Subject: A/180/21/DOC - Mayflower Way, Angmering - Construction Management Plan

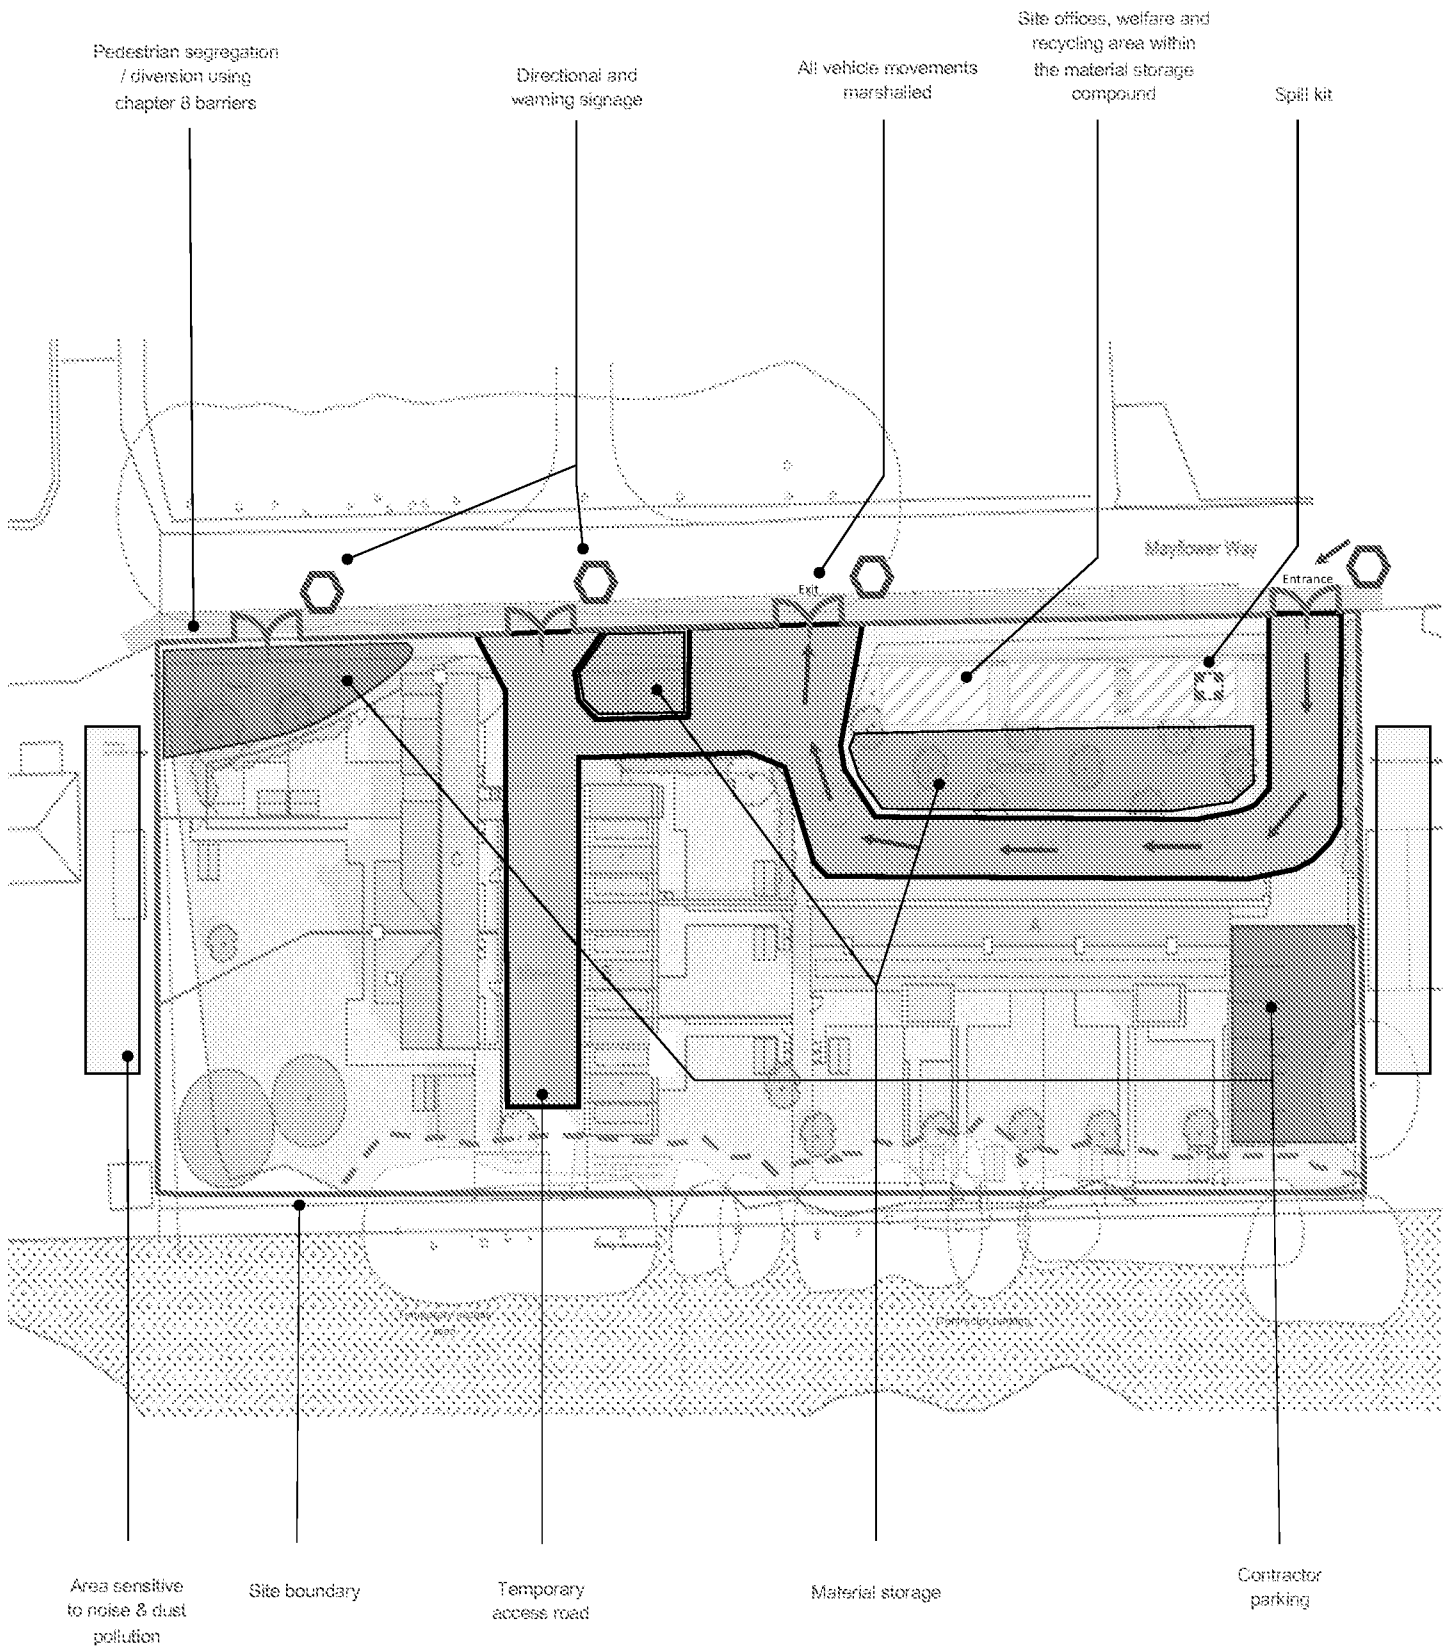
No agreement to discharge of Condition 6. The applicant will be aware of the predominantly peaceful nature of this area. It is therefore of concern to note that both access to the site materials storage area, (which will include HGV deliveries/taking away) and to contractor car parking is proposed along the boundary with a bungalow/housing to

the immediate east of the proposed new housing. There is a similar, but smaller, area of contractor parking proposed immediately onto the boundary with that property to the immediate west of the site.

The location of the site access way/materials storage is therefore far from ideal and in my opinion likely to result in noise detriment/nuisance to nearby sensitive receptors. I would request for the site access way and main materials store to be repositioned to a more central position along Mayflower Way. Perhaps, it would then be possible for the main area of contractor parking to be brought forward towards Mayflower Way to form a buffer to this bungalow. Please could the applicant describe the type of vehicles which will be included in 'contractor parking' ie will this be for vans and private cars alone/other.

I would therefore request that you submit a revised site layout plan and details to address these concerns within the next 10 days. I would appreciate your agreement to an extension of time on the application until 10-11-2021 to allow for submission of revised details and re-consultation.
